DRAWING MARKED-UP TO SHOW PROPOSED AMENDMENTS

Project  
4 Bellingham Road

Title  
Proposed Second Floor Plan

Drawing no.  
2002 - M - 612

Drawing no.
2002 - PL - 612

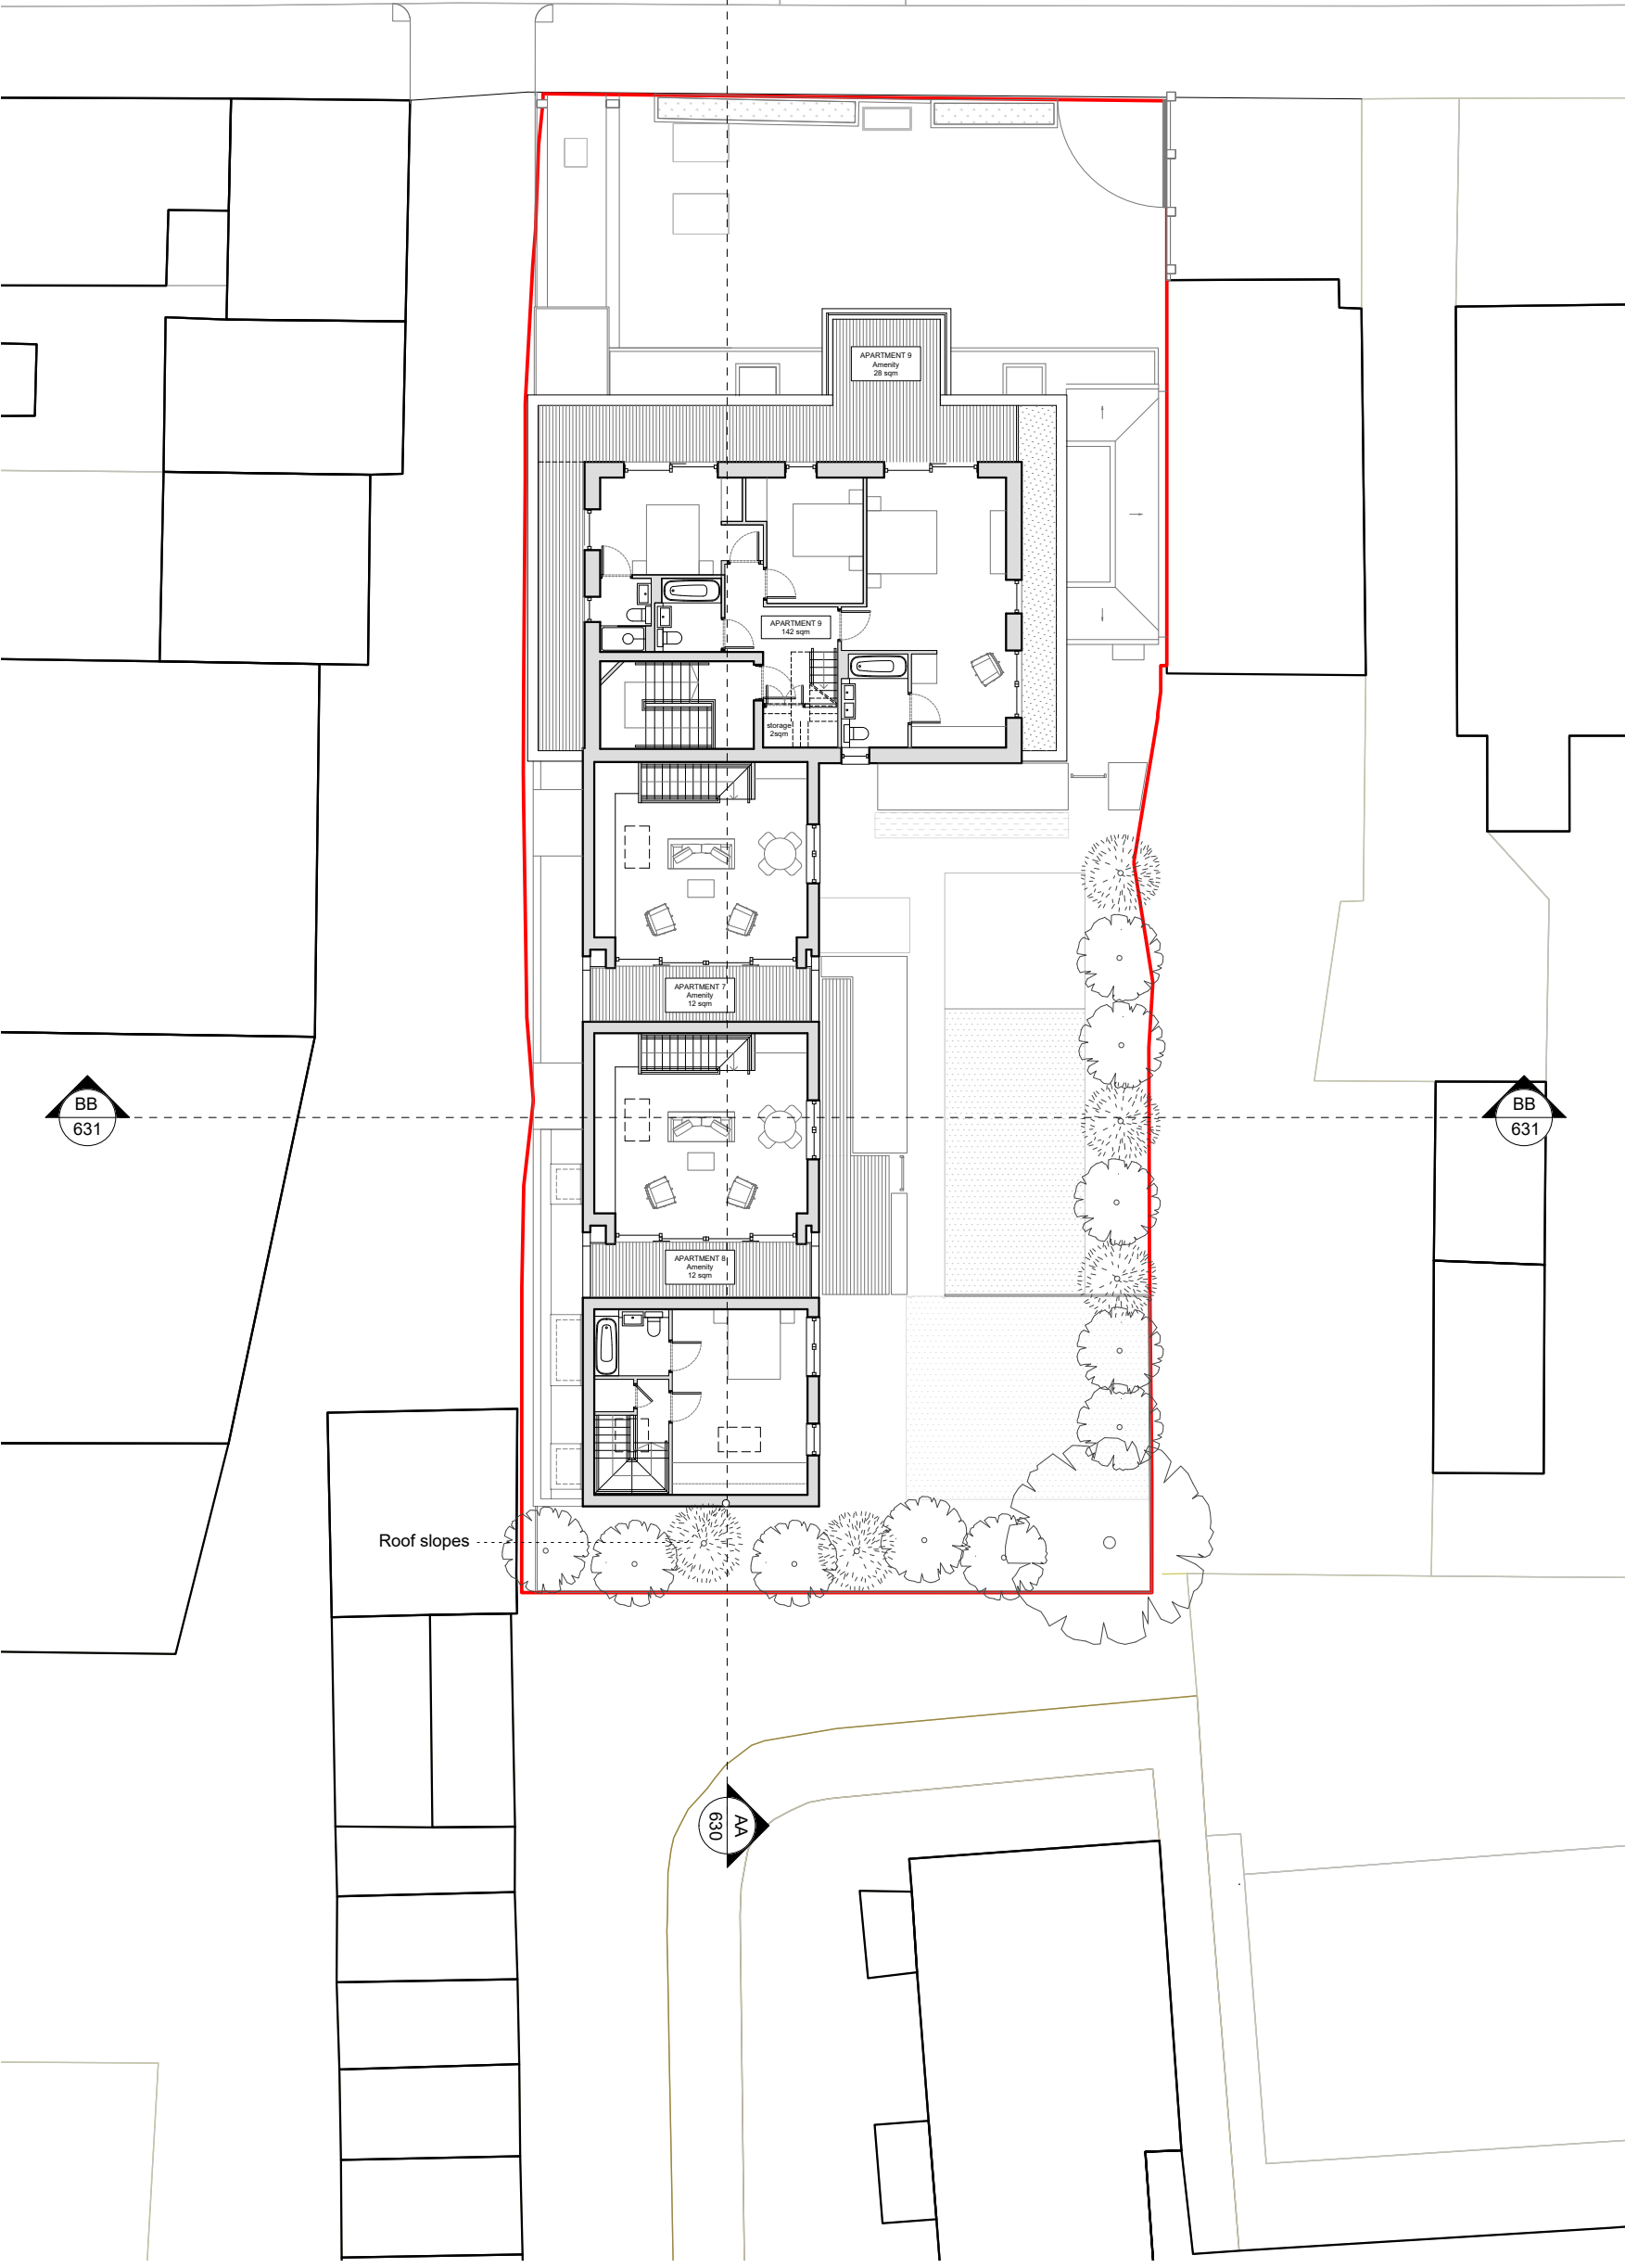
Exterior amenity space extended to second floor level

Interior layout reconfigured to provide additional bedroom accommodation and stair to third floor level

Roof slopes
